November 25, 2025

**RE: Farolito Senior Community  
10501 Central Ave NE  
30-day Temporary Certificate of Occupancy  
Engineer's Certification Date: 11/19/25  
Engineer's Stamp Date: 09/15/2023  
Hydrology File: L21D074  
Case # HYDR-2025-00414**

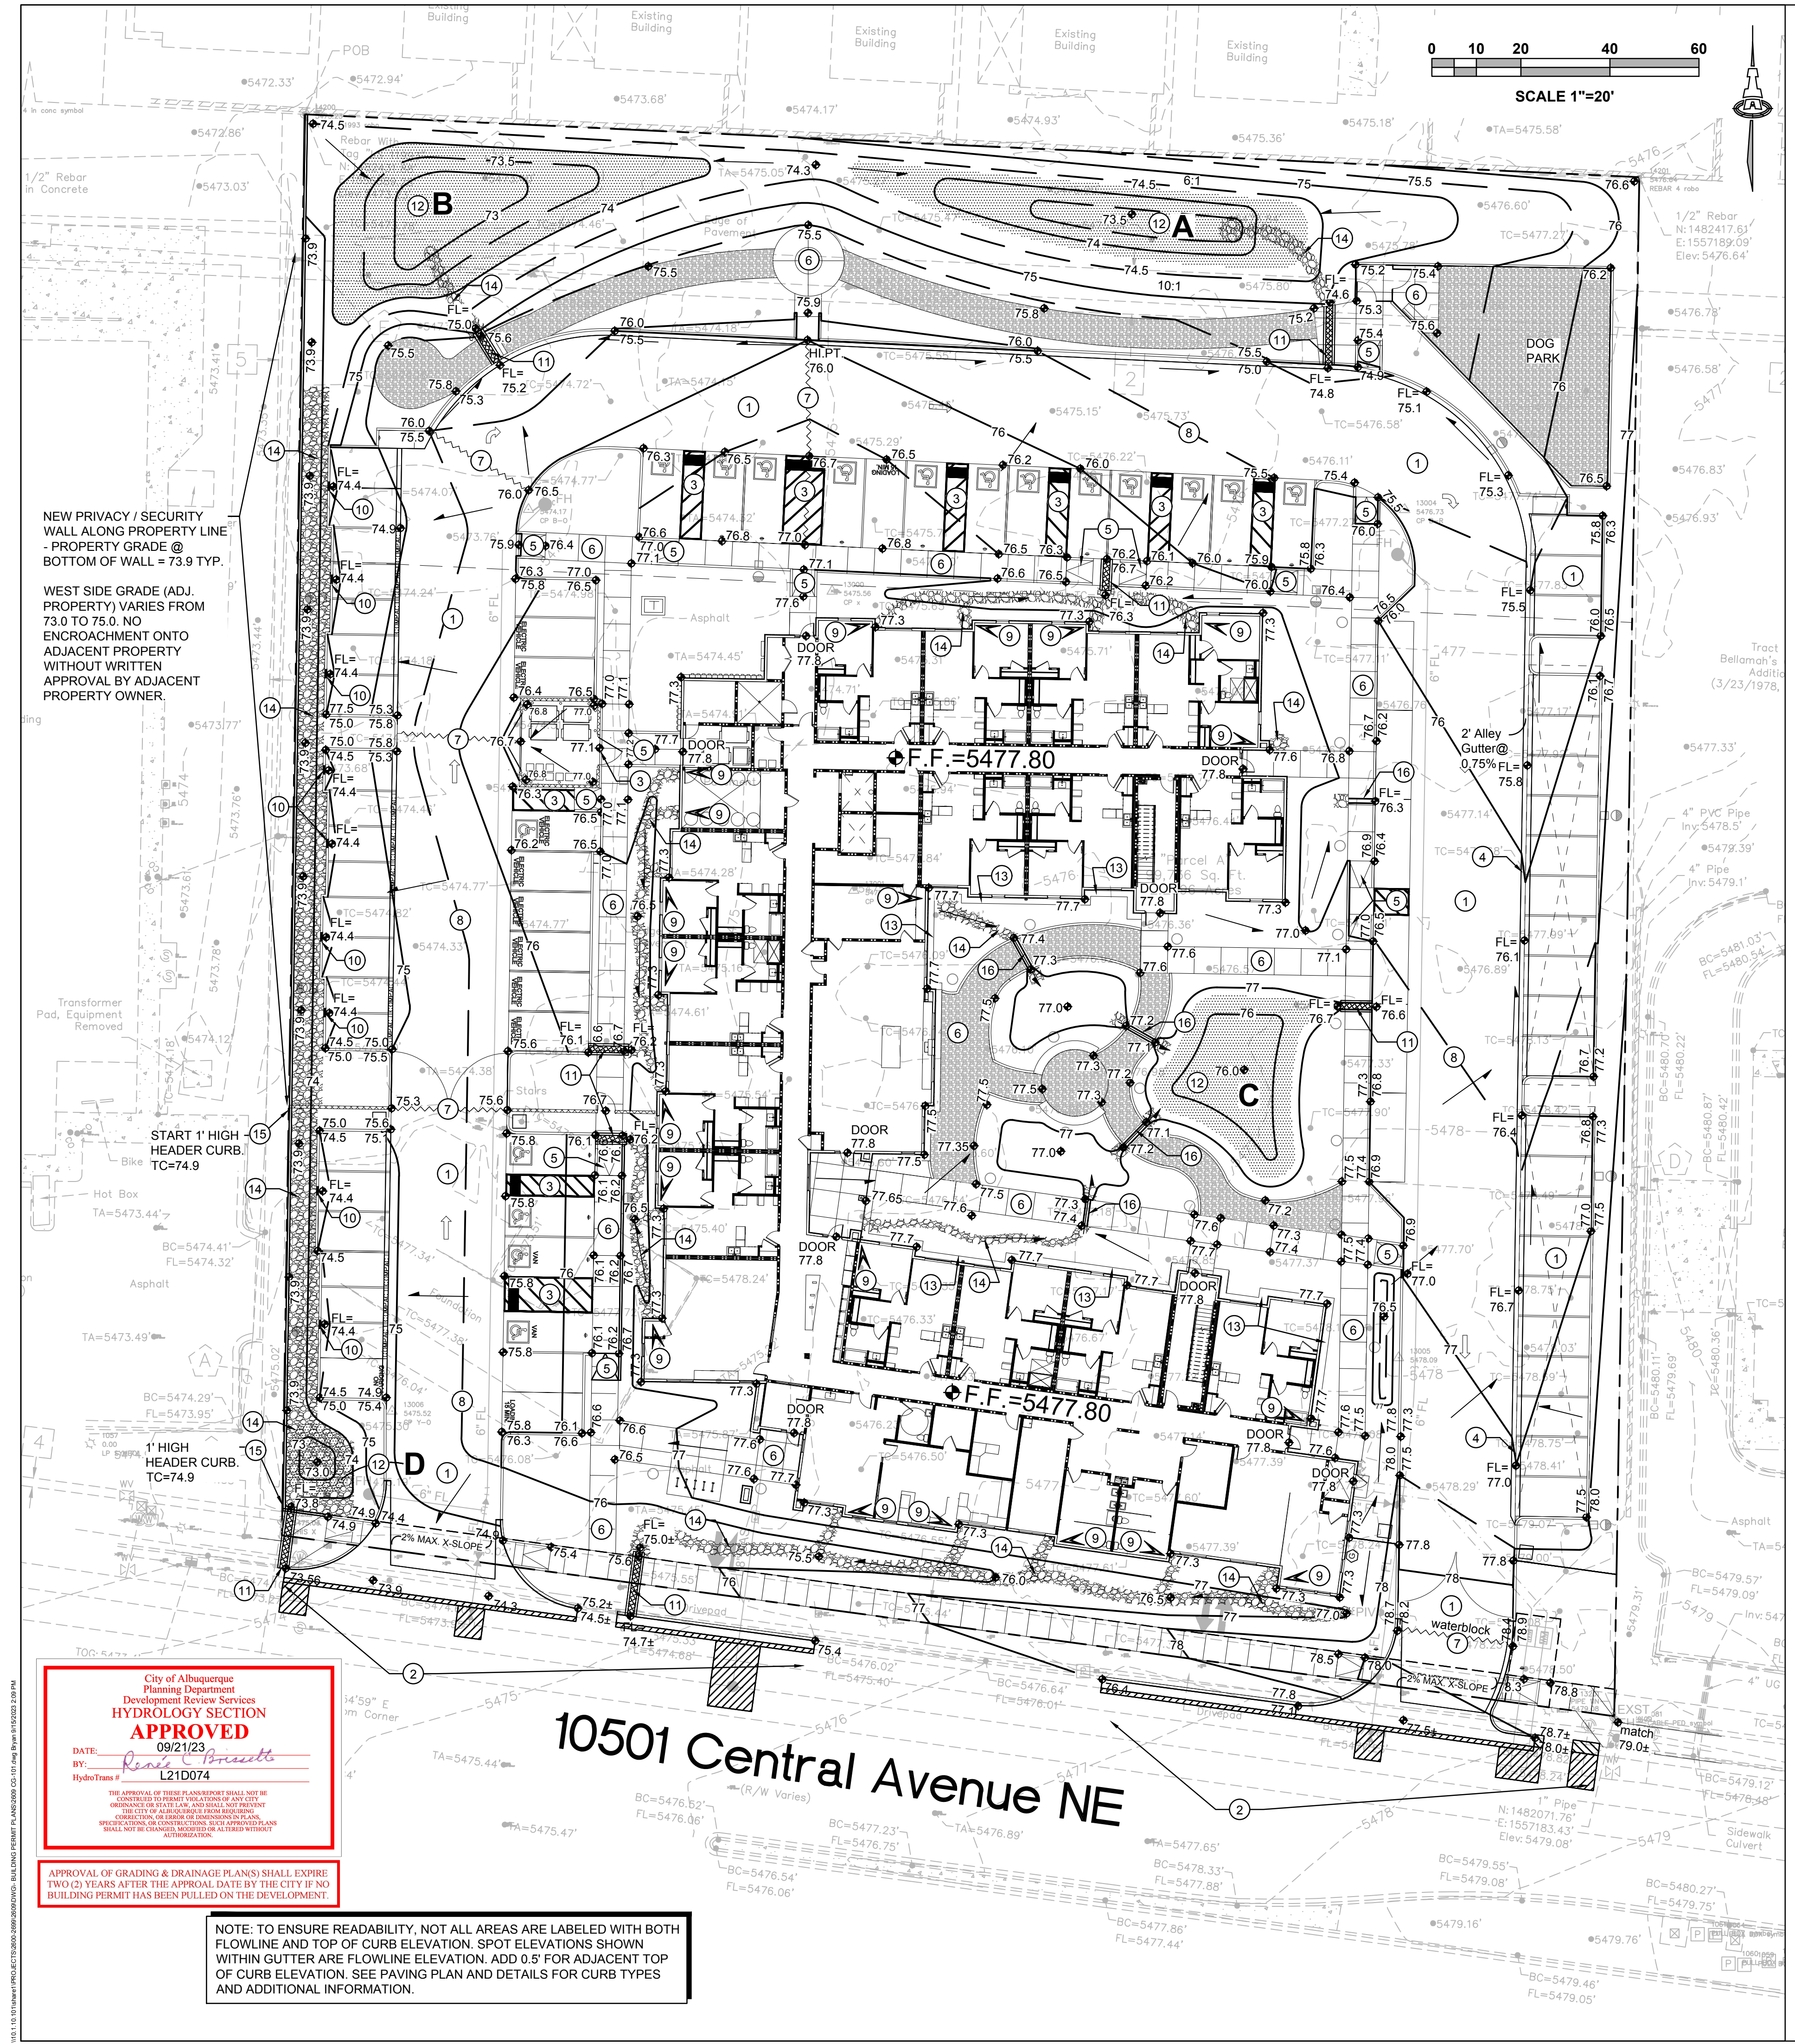
1. Please add a curb cut to allow water to enter Pond A.
